# CITY OF ALBUQUERQUE

**Re: Carlisle Crossing – 2100 Carlisle NE  
Erosion and Sediment Control Plan  
Engineer's Stamp Date 6/14/2021 (H17E097)**

Based upon the information provided in your submittal received on 6/21/21, the above-referenced plan is approved to be included in the SWPPP and the Work Order plans.

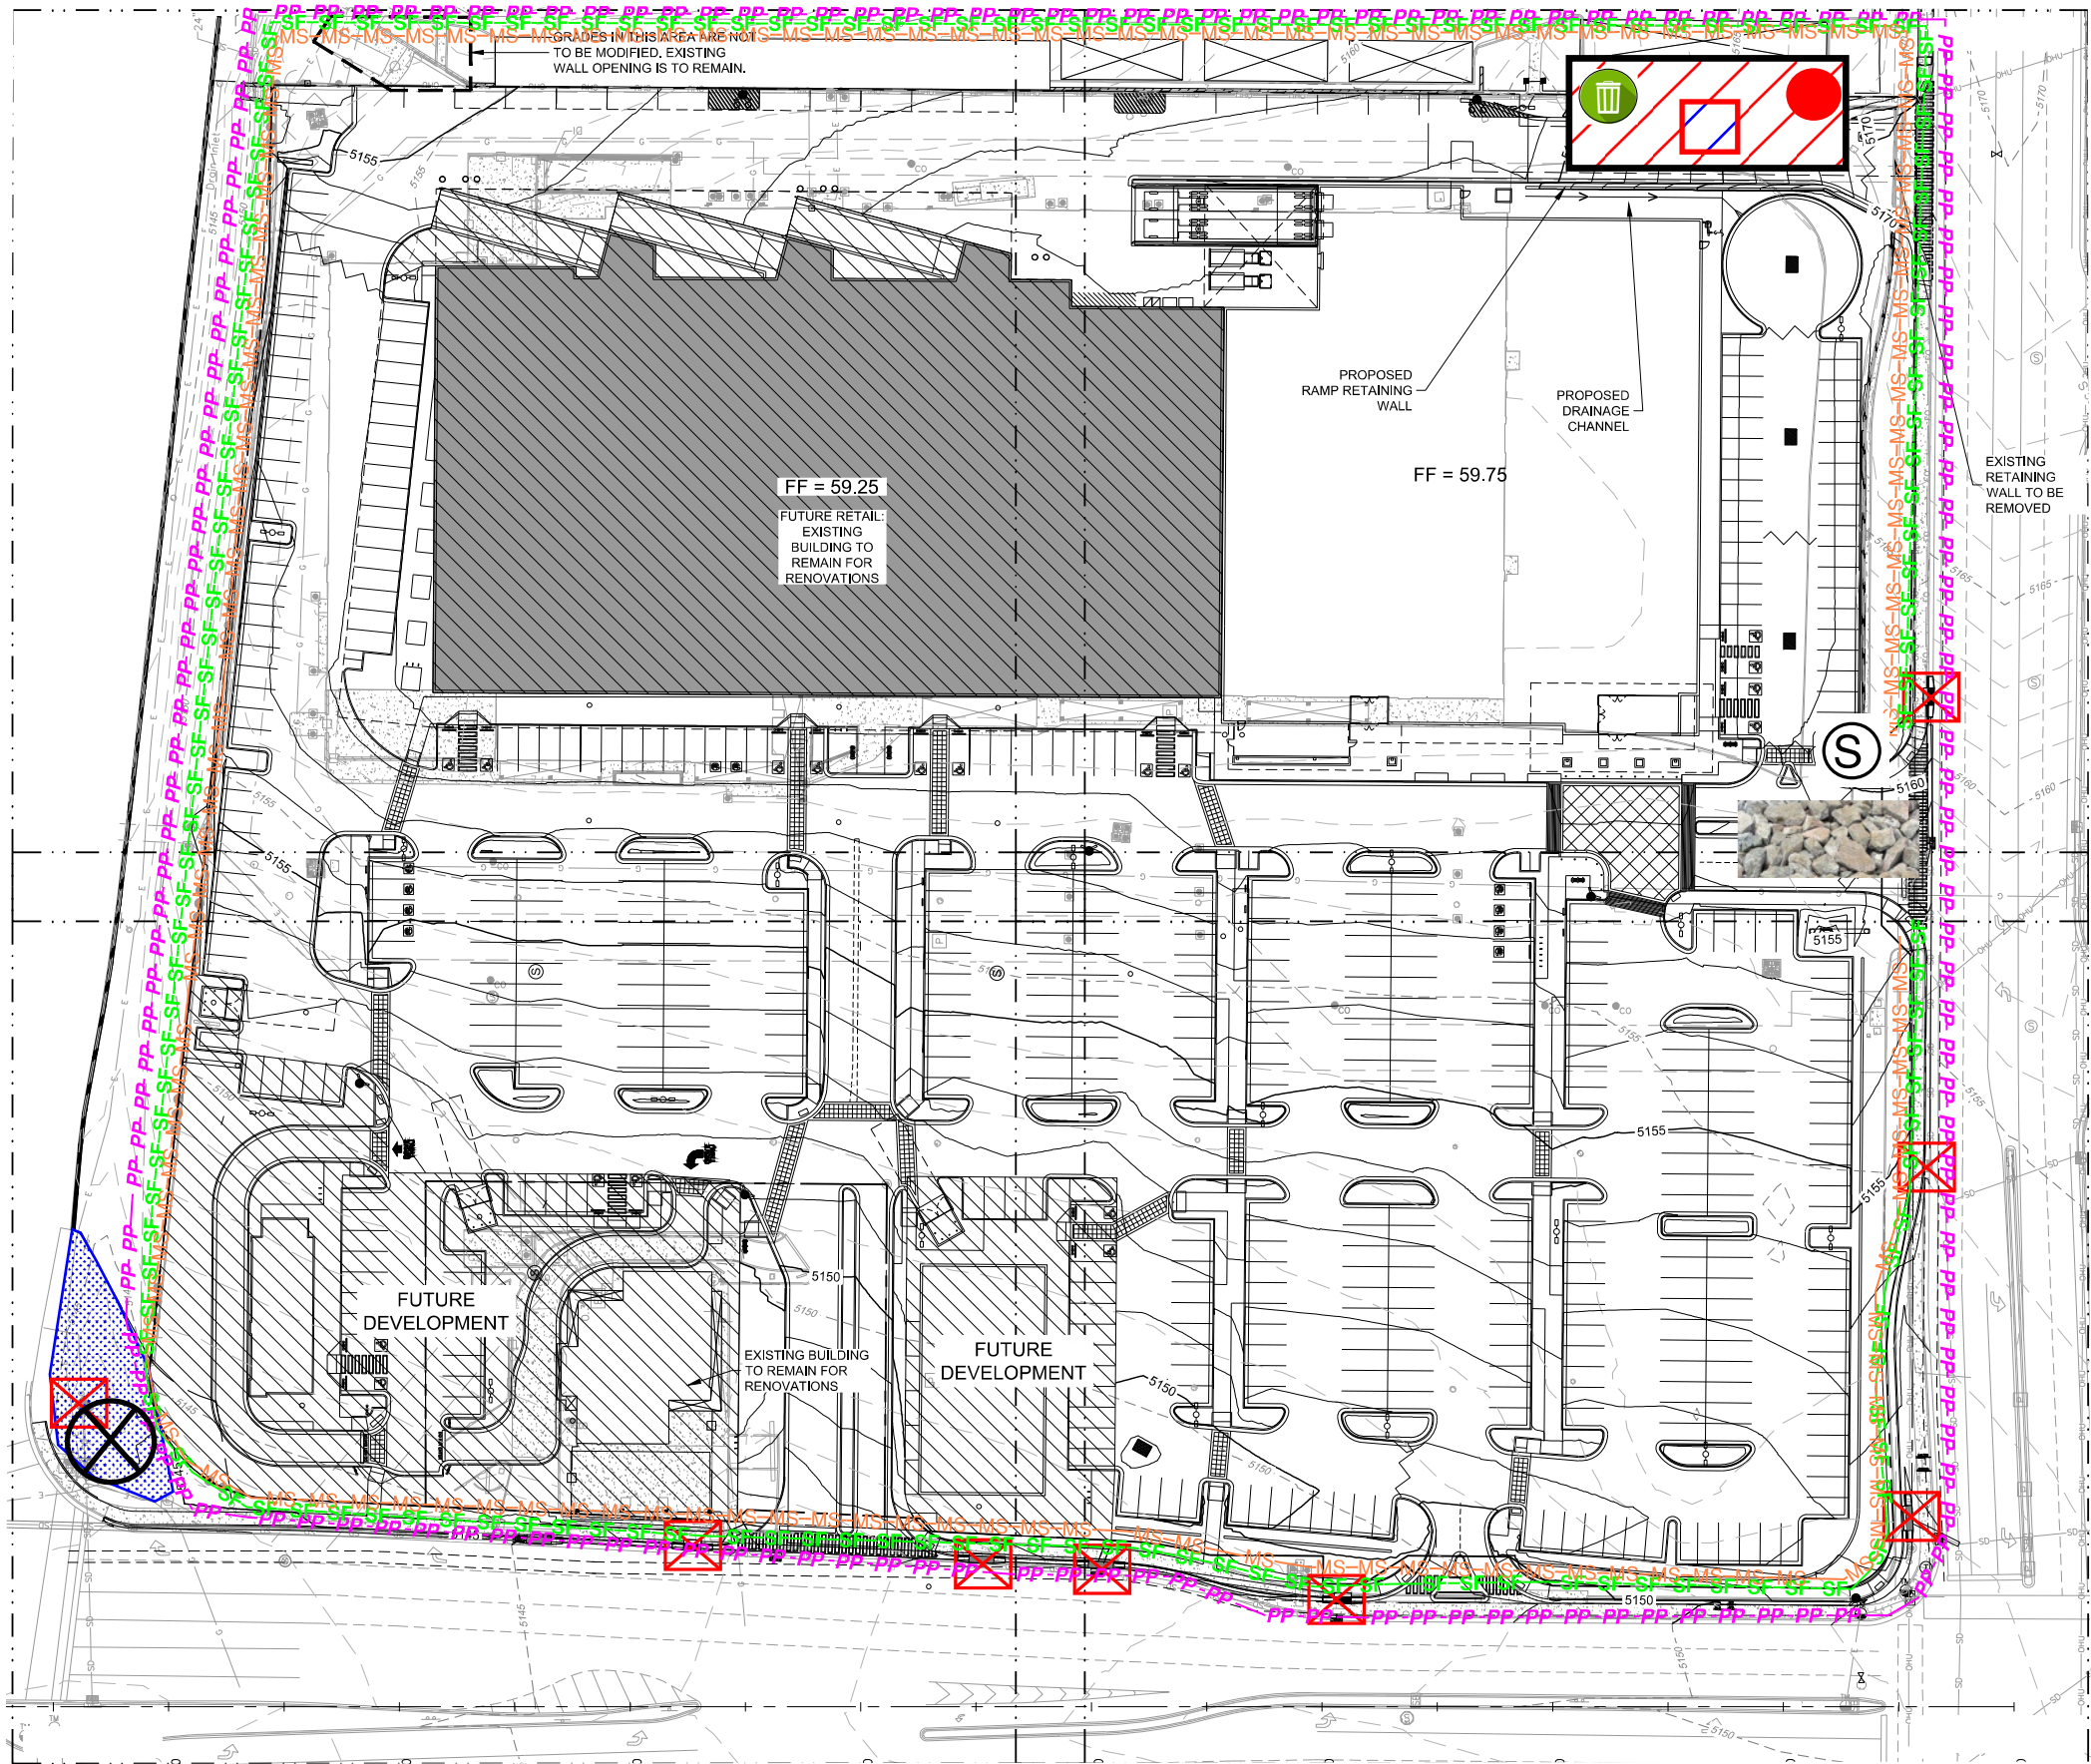
1. The ESC Plan can't be approved for Grading, Building Permit, or Work Order until the Grading and Drainage Plan is approved by hydrology for each of those purposes. An individual plan may be provided for each goal. The existing and proposed grades must be shown on the plan, and they must agree with the Grading Plan approved by Hydrology (CGP7.2.4.b.ii);

2. Identify the stormwater discharge points on the plan.
3. This site is too big for silt fence alone [Stormwater Best Management Practice: Silt Fences: design, installation, maintenance, inspection: April 2012 \(epa.gov\)](https://www.epa.gov/stormwater/best-management-practices).  
Temporary sediment traps or sediment basins must be located at each stormwater discharge point. Temporary diversion berms should be used to divert drainage into the sediment traps. Silt fences may be used for sheet drainage provided that the length of the slope is less than 300' and provided that the Silt fence is constructed according to the City standard detail with the silt fence embedded 12" into compacted soil and installed on contour with the ends wrapped uphill to pond water behind the silt fence. Wattles may be used where the slope length is less than 50' and must be staked at intervals of 4'.

4. Describe the nature and extent of construction activities for each operator (CGP 7.2.2.), including a) nature of construction activities, b) size of the property, c) size of disturbed area, d) description of construction support activities, e) size of maximum disturbed area, and f) Project Schedule. Please include a description of each phase, including g) Work Order frontage improvements, h) onsite demolitions of the parking lot and buildings, i) future development, j) building construction and remodel, k) parking lot construction, and landscaping.

5. Phases may need to be shown on different sheets for clarity. It seems that the Work Order Plans will be the first phase of construction, so consider developing an ESC Plan showing only the work that will be done with that phase and the corresponding erosion controls and construction support activities such as a staging area and

stockpile area. And show the rest of the 11-acre site as being “future construction see separate Plan.” Later phases may be processed for approval later.

6. Show the Limits of Land Disturbing activities on the ESC Plan for each phase and provide a demolition plan on a map of existing conditions showing all of the impervious surfaces to be removed.

8. Soil information – add a table with name type, particle sizes, and Erodibility factor (CGP 2.1.1).
9. Update the engineer's stamp date each time the plan is changed.
